Application for a Non-Material Amendment Following a Grant of Planning Permission

Transport House

Removal of existing pitched roof and addition of a second floor to provide 2 x 1 bed and 1 x 2 bed residential units

17502/APP/2020/4148

SCALE	1:100 @ A3	DRAWING NUMBER	REV.
DATE	JUL 2020		
DRAWN	BM	1134-03	D

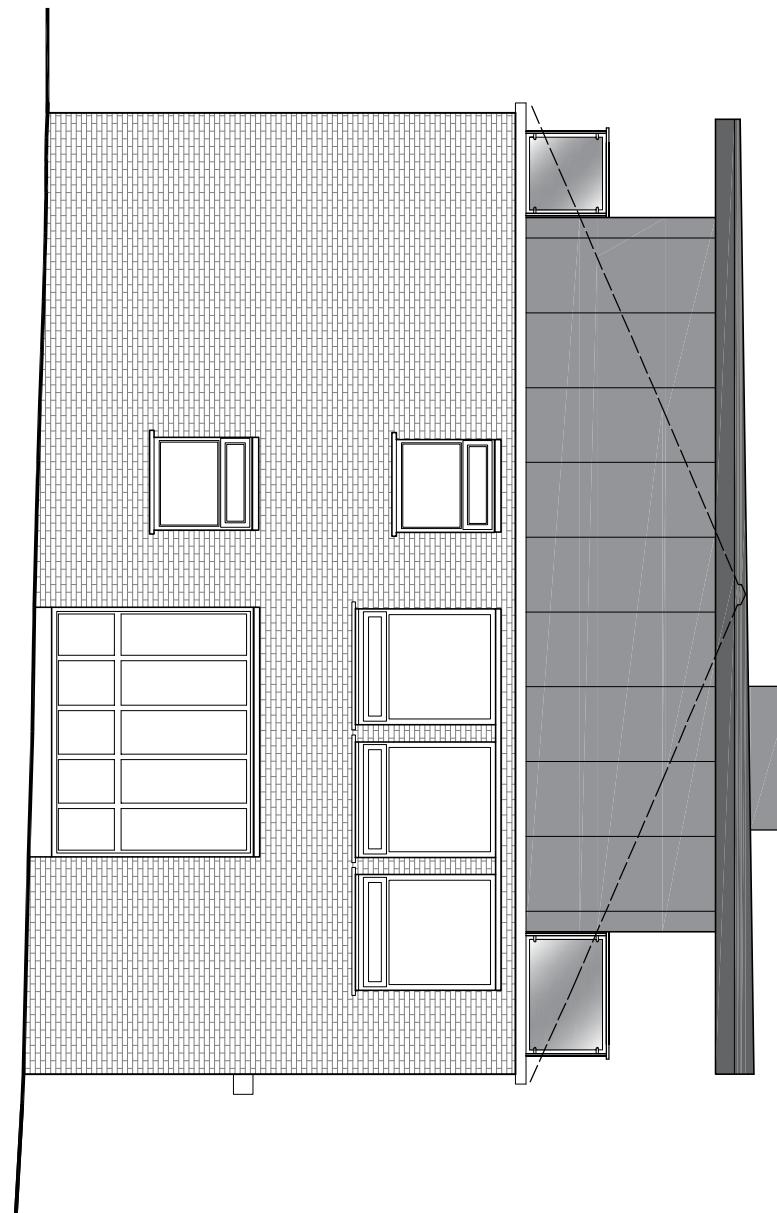
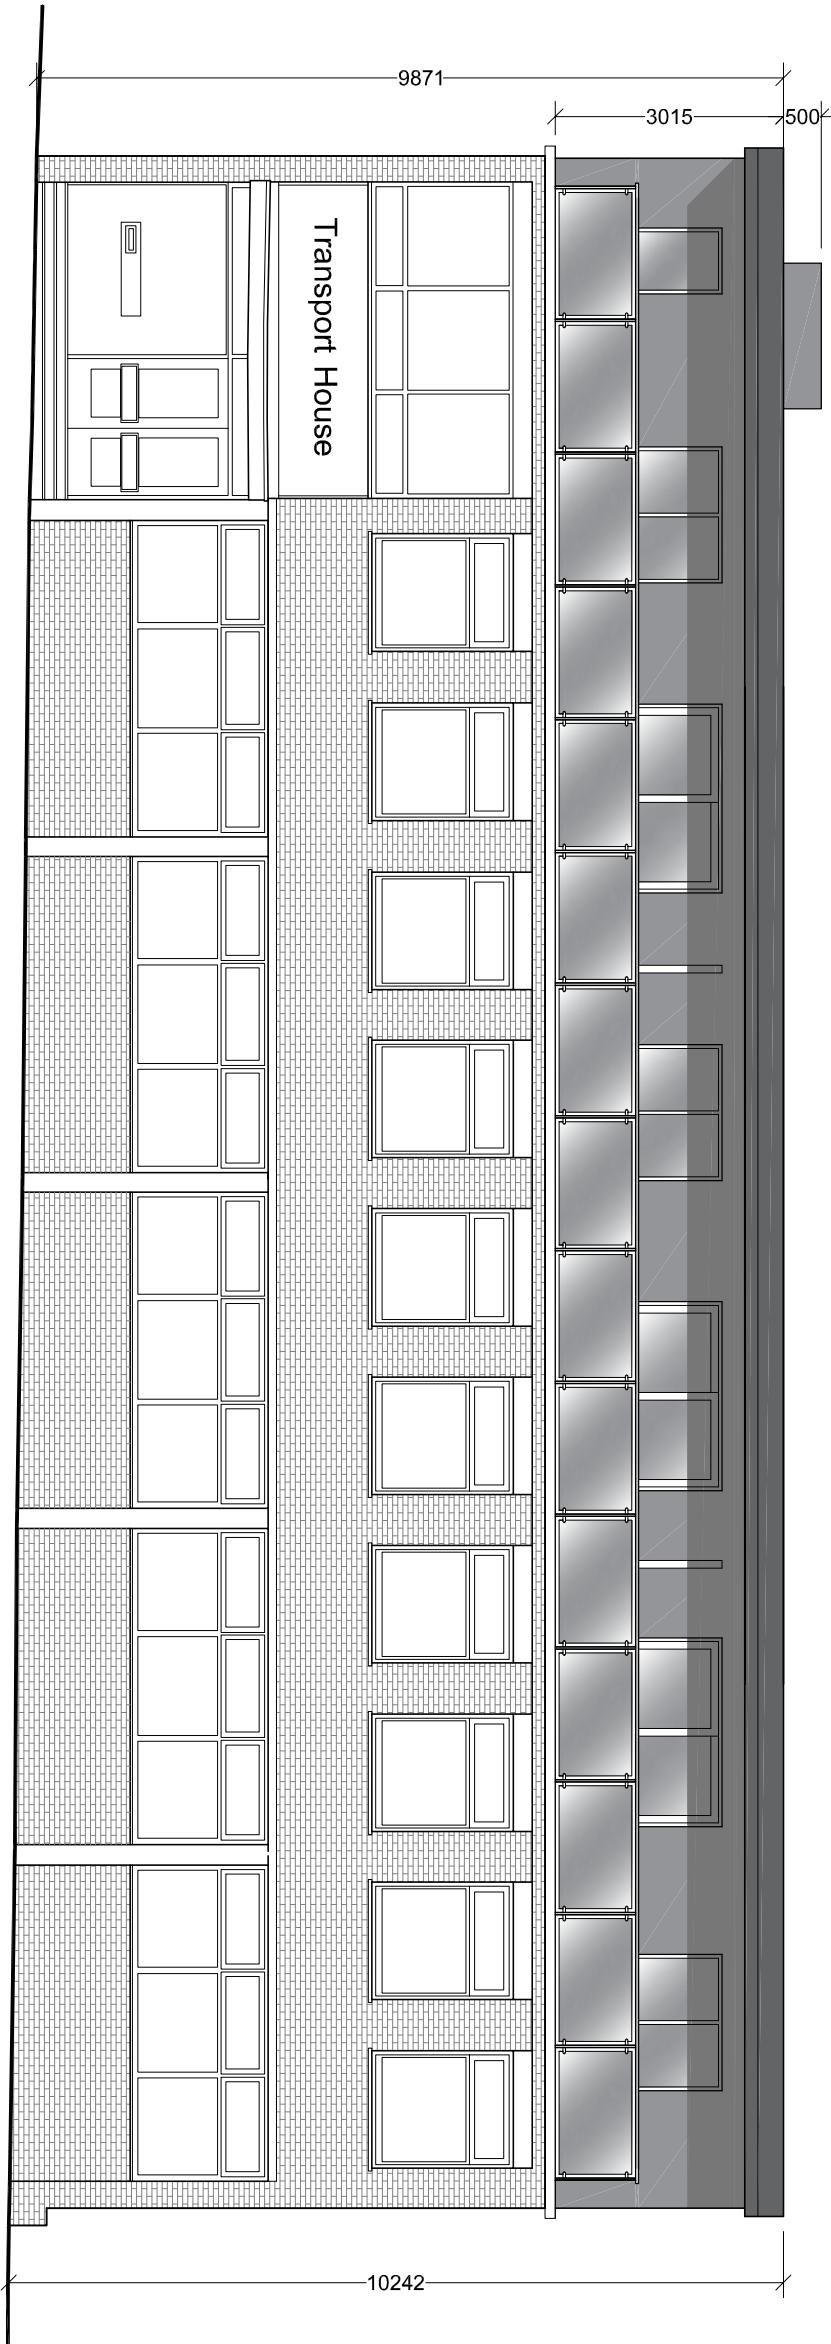
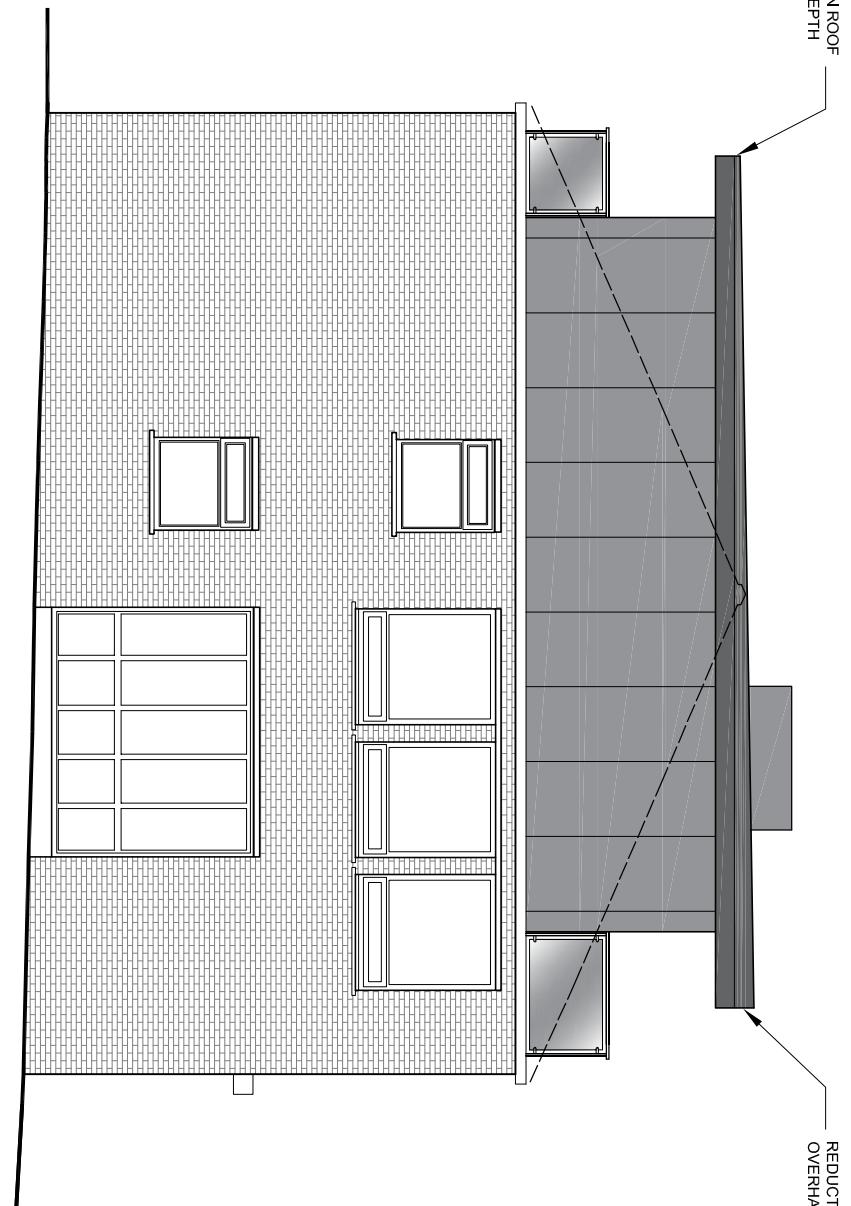
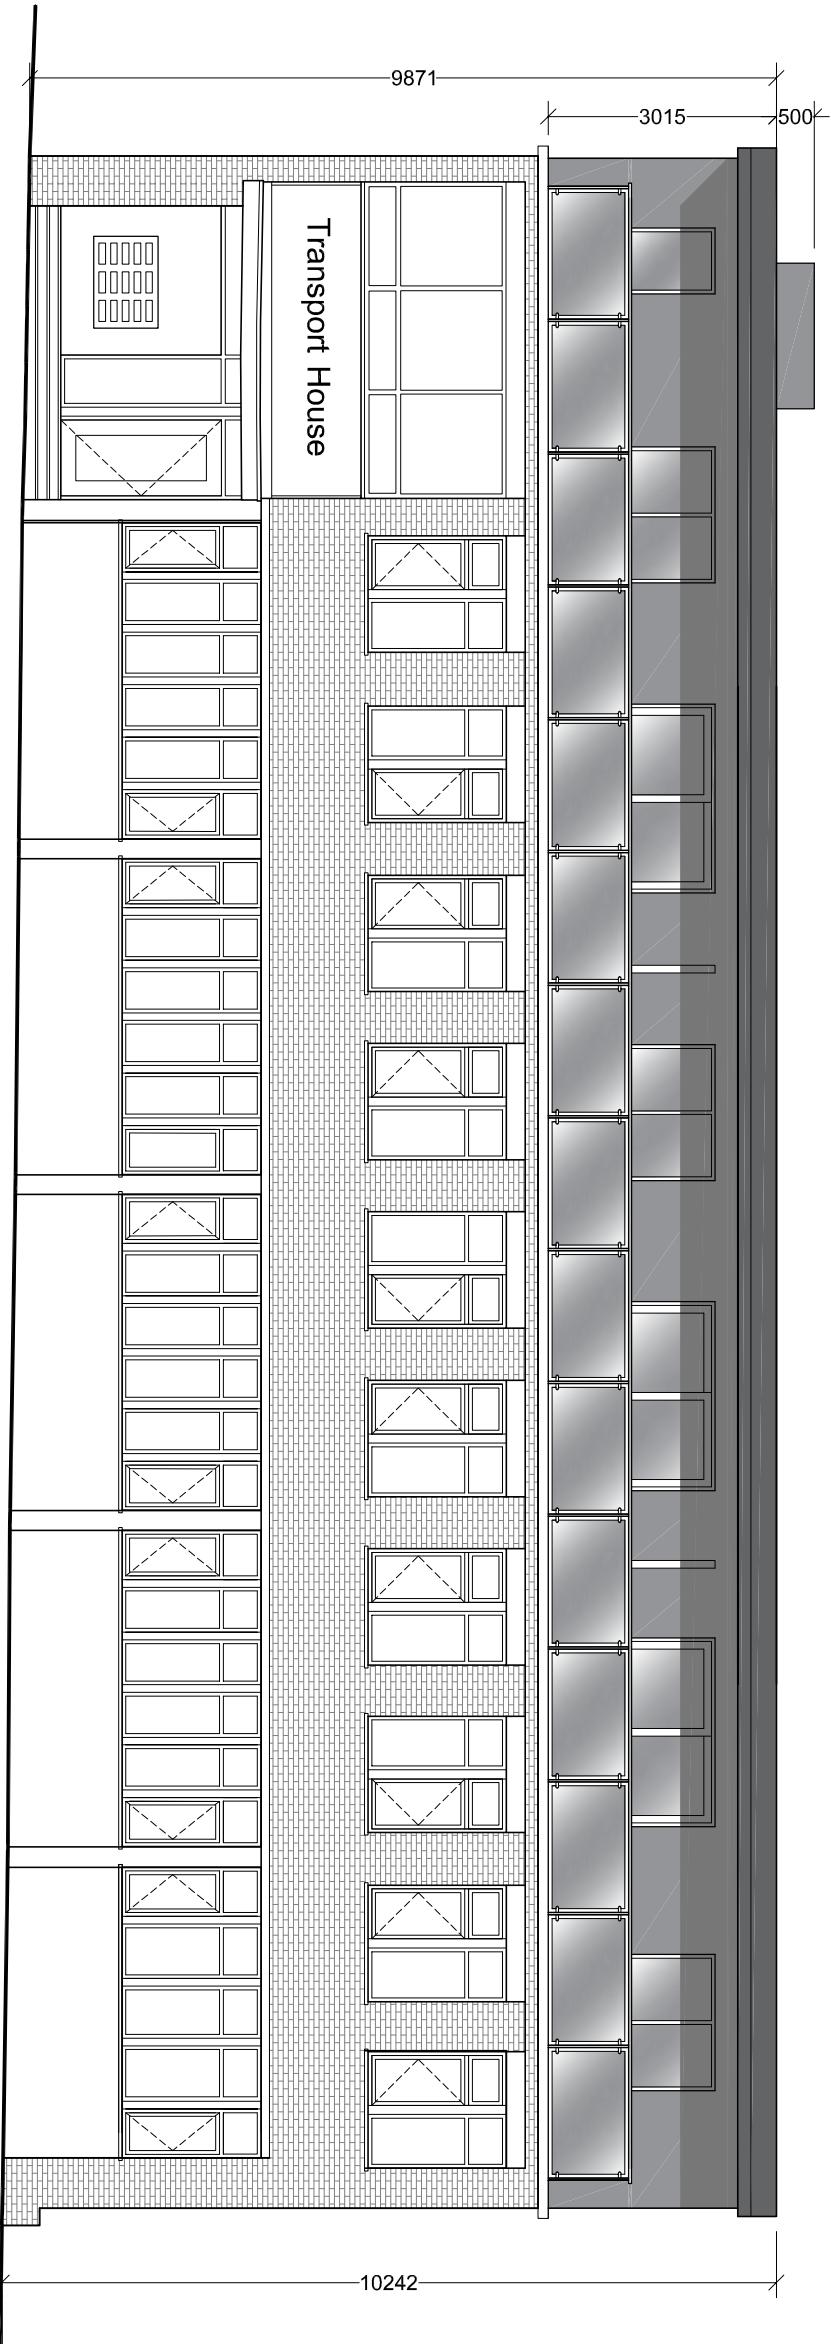
The original office toilet windows are at high level and need to be lowered to provide suitable amenity for the residents of the new flats.
The emergency exits are also no longer required.
The existing windows throughout are old white UPVC and need to be upgraded to current U-Values and to achieve required acoustic levels.
The new replacement windows shall be grey UPVC to match the approved windows and doors on the new top floor.
The proposed roof overhang is being reduced slightly at the front and rear of the building due to structural concerns over forming the overhangs to the depths shown on the approved plans.

1134-3E and 1134-04E
